**Prince of Wales Hospital Expansion Stage 1 (SSD 9113)
Satisfaction of Condition A18 – Emergency Department Car Park Screening**

The Department has reviewed the plan titled Emergency Carpark B2 Car Headlight Spill Extent, dated 31 January 2020, by Aspect Studios and is satisfied with the proposed screening structure (i.e. landscaped mound).

EMERGENCY CAR PARK

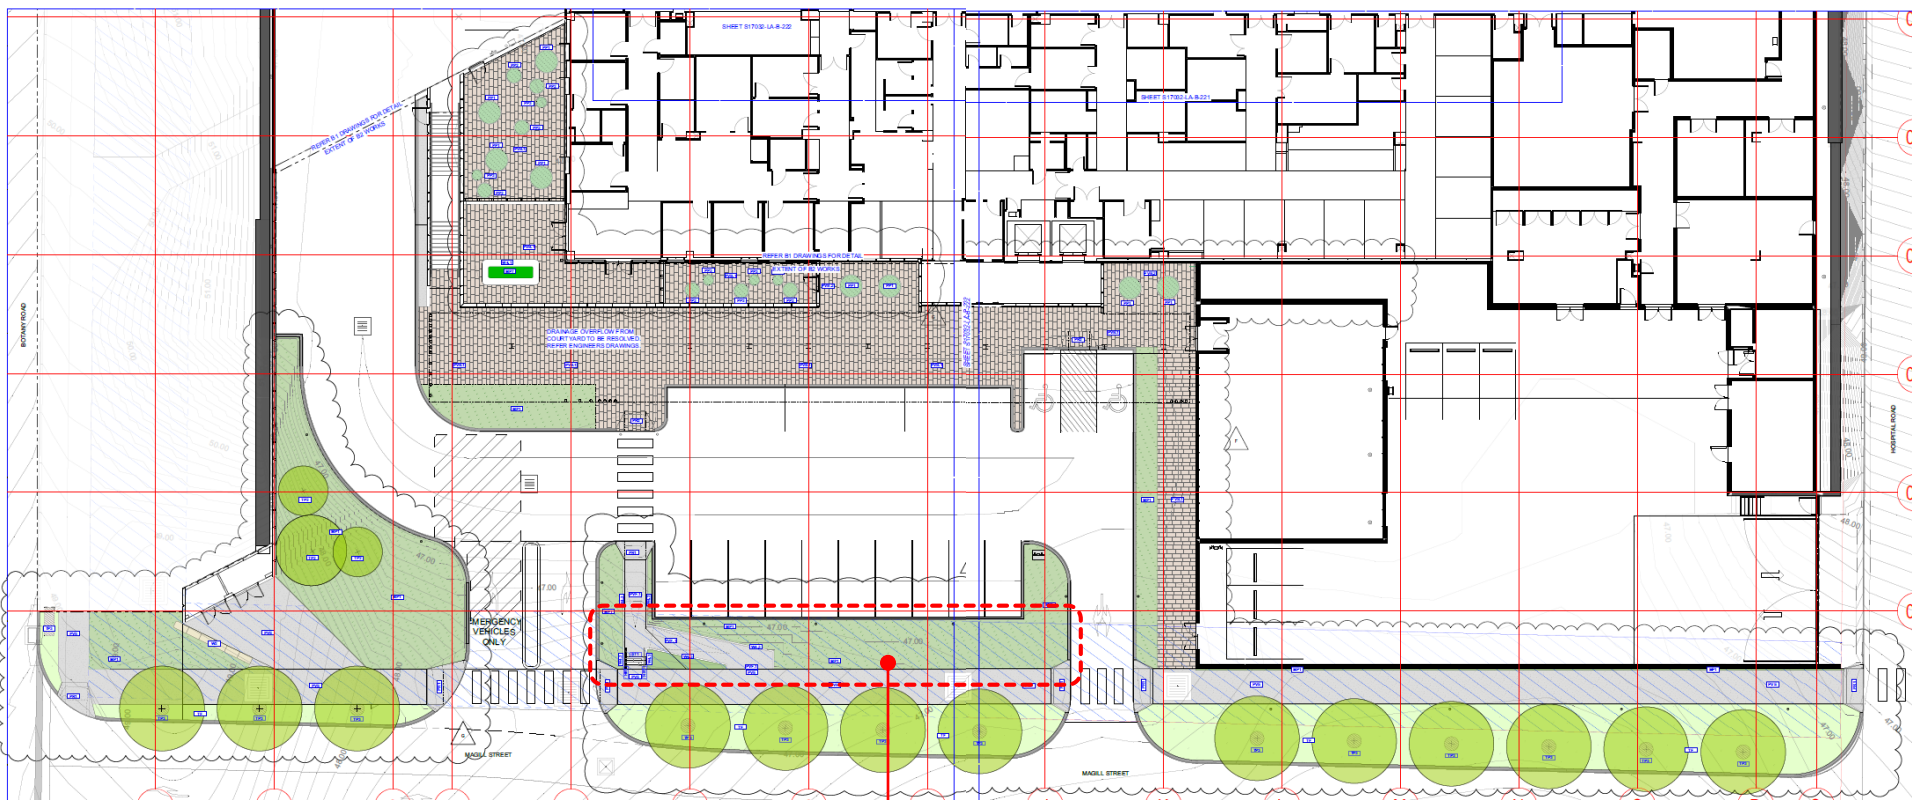
Accordingly, the requirements of condition A18 have been fully satisfied provided that the finished landscape mount is built to the height shown on the plan referenced above and the landscaping (dense shrub planting) planted and maintained in perpetuity.
